City of Albuquerque

**RE: DOWNTOWN DAYCARE (J14/D111) DRAINAGE AND GRADING PLAN
SUBMITTAL FOR BUILDING PERMIT AND SO-19 APPROVAL.
ENGINEER'S STAMP DATED 8-15-95.**

**RE: DOWNTOWN DAYCARE (J14/D111) DRAINAGE AND GRADING PLAN
SUBMITTAL FOR BUILDING PERMIT AND SO-19 APPROVAL.
ENGINEER'S STAMP DATED 7-15-95.**

GRADING AND DRAINAGE PLAN DOWNTOWN DAYCARE

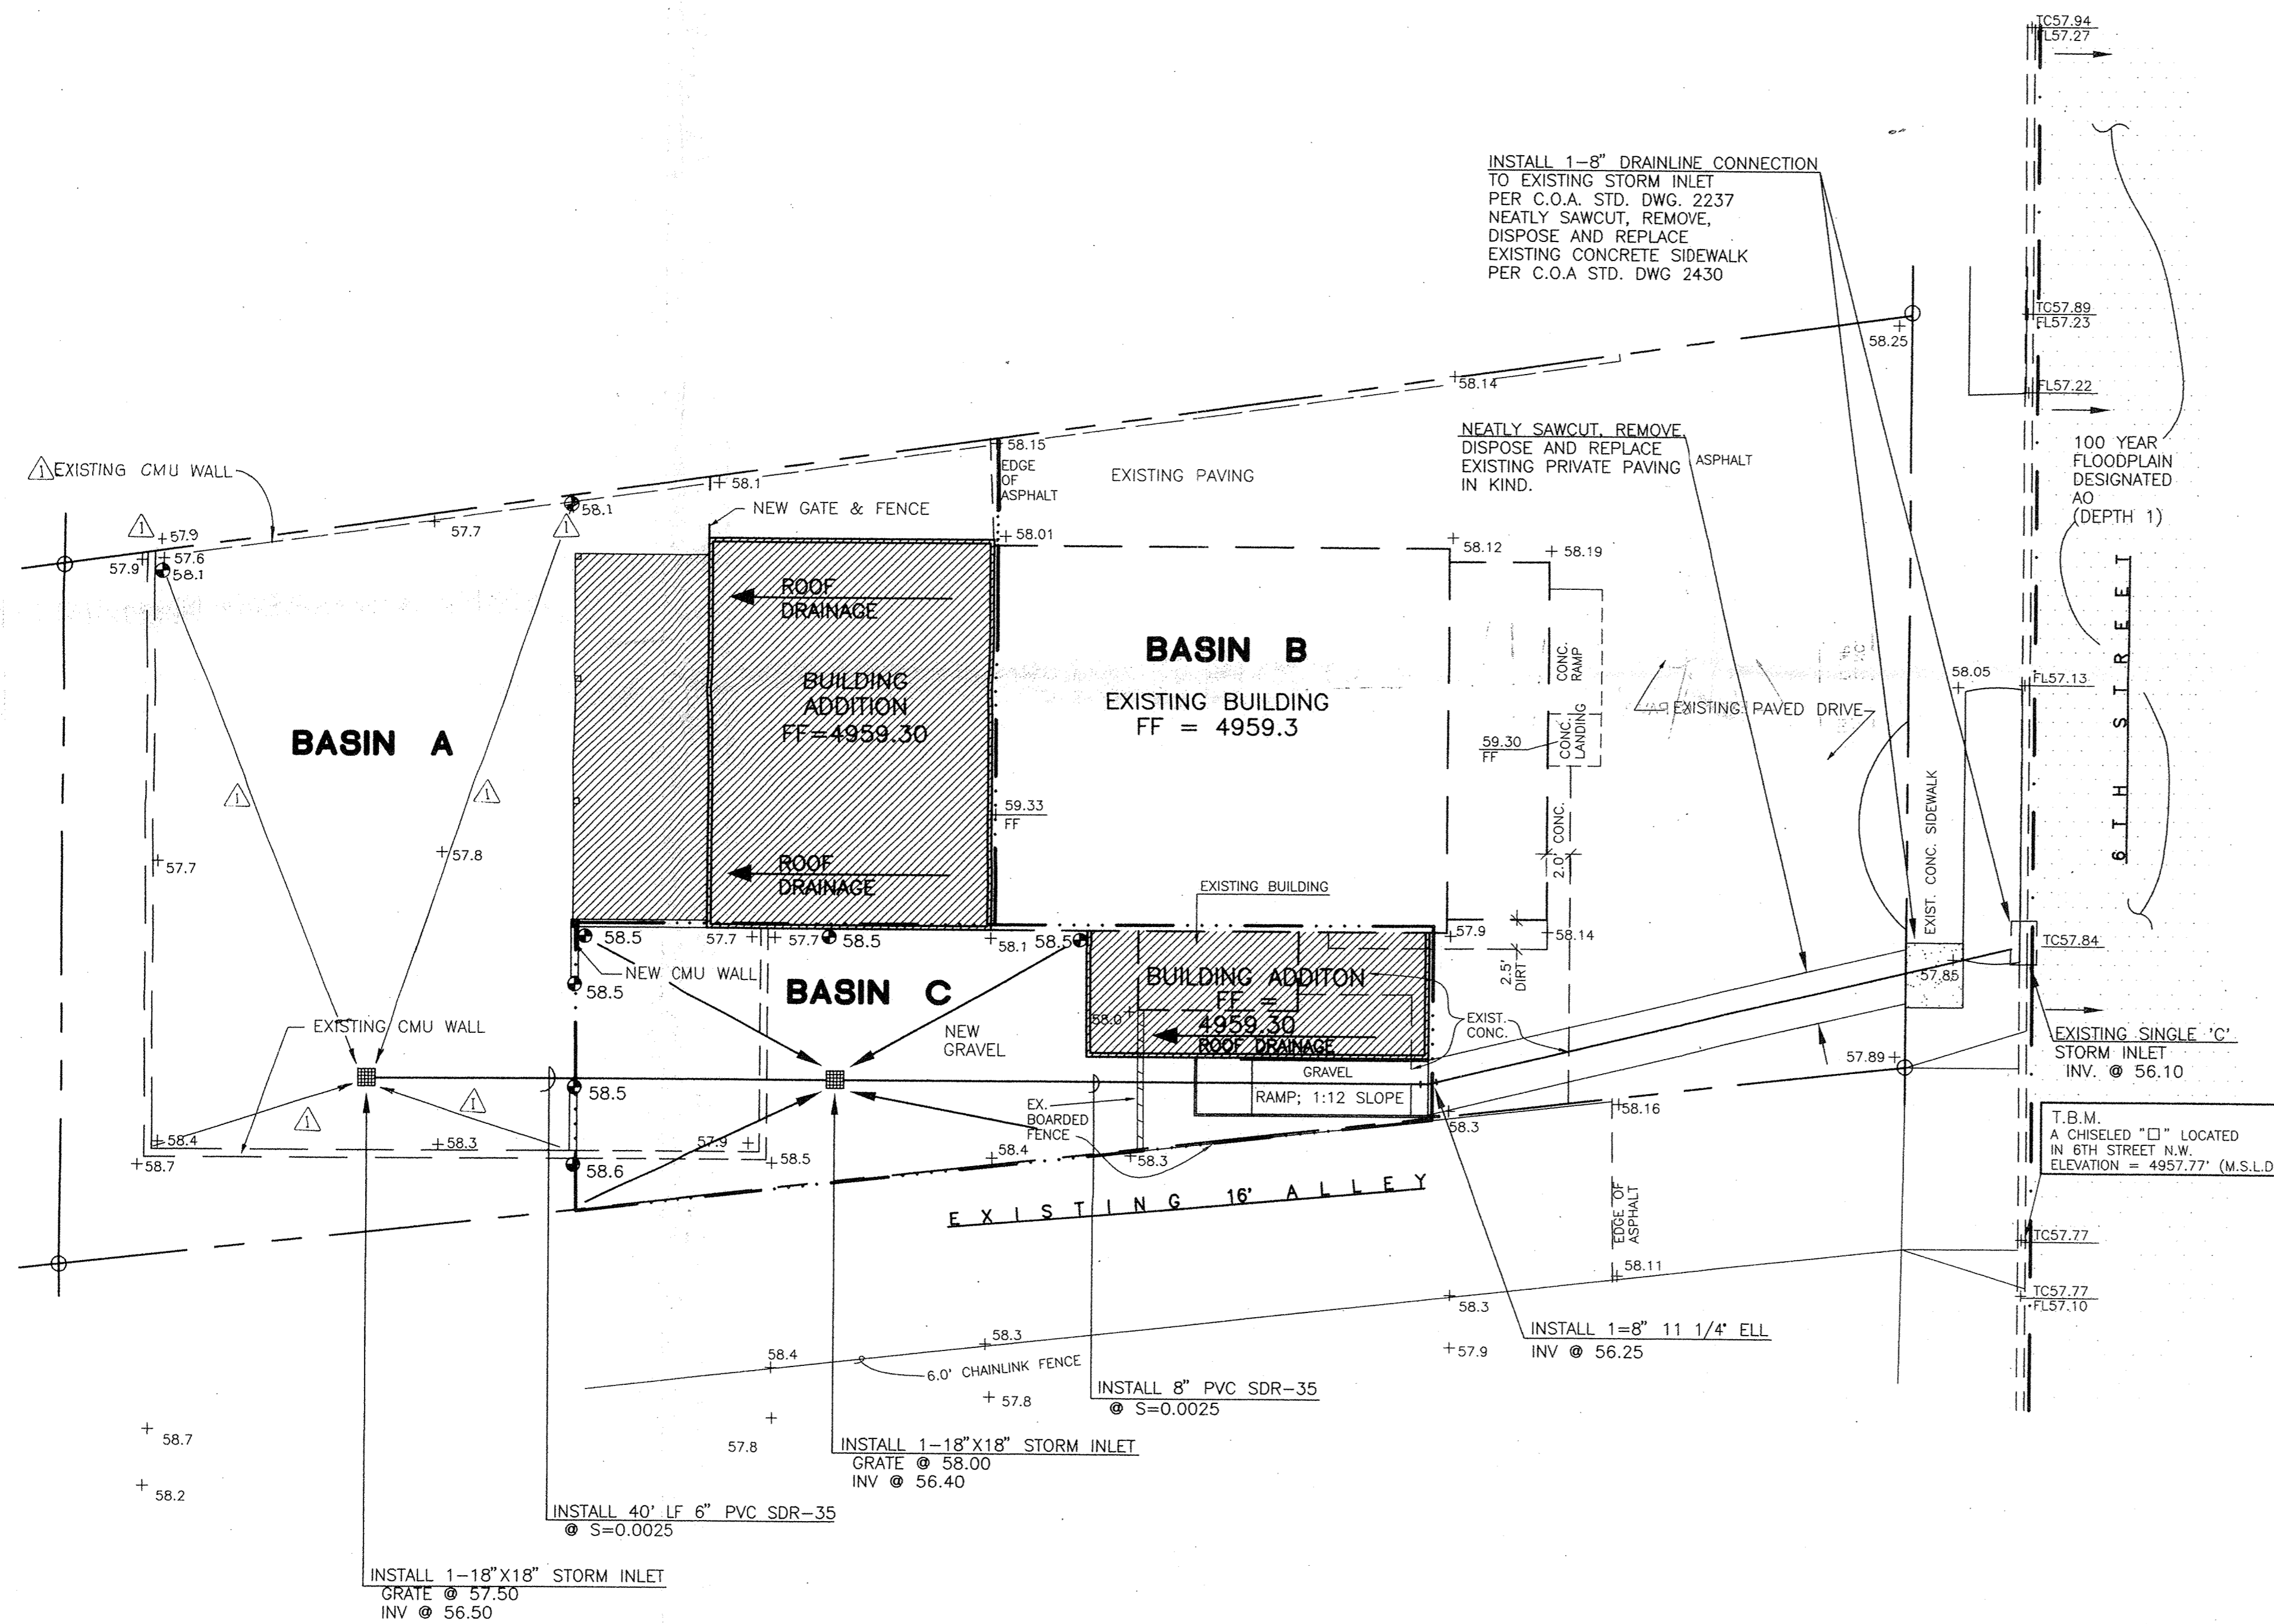
Approximately 2000 square feet of gravel area located in the north half of Basin "A" is retaining water. This area should be regraded to drain to the new inlet.

Because of the owner's responsibility to maintain the storm drain system, the size of pipe used (40 feet of 6 inch PVC), and the installation of an 8 inch elbow, you may want to consider installing some clean-outs.
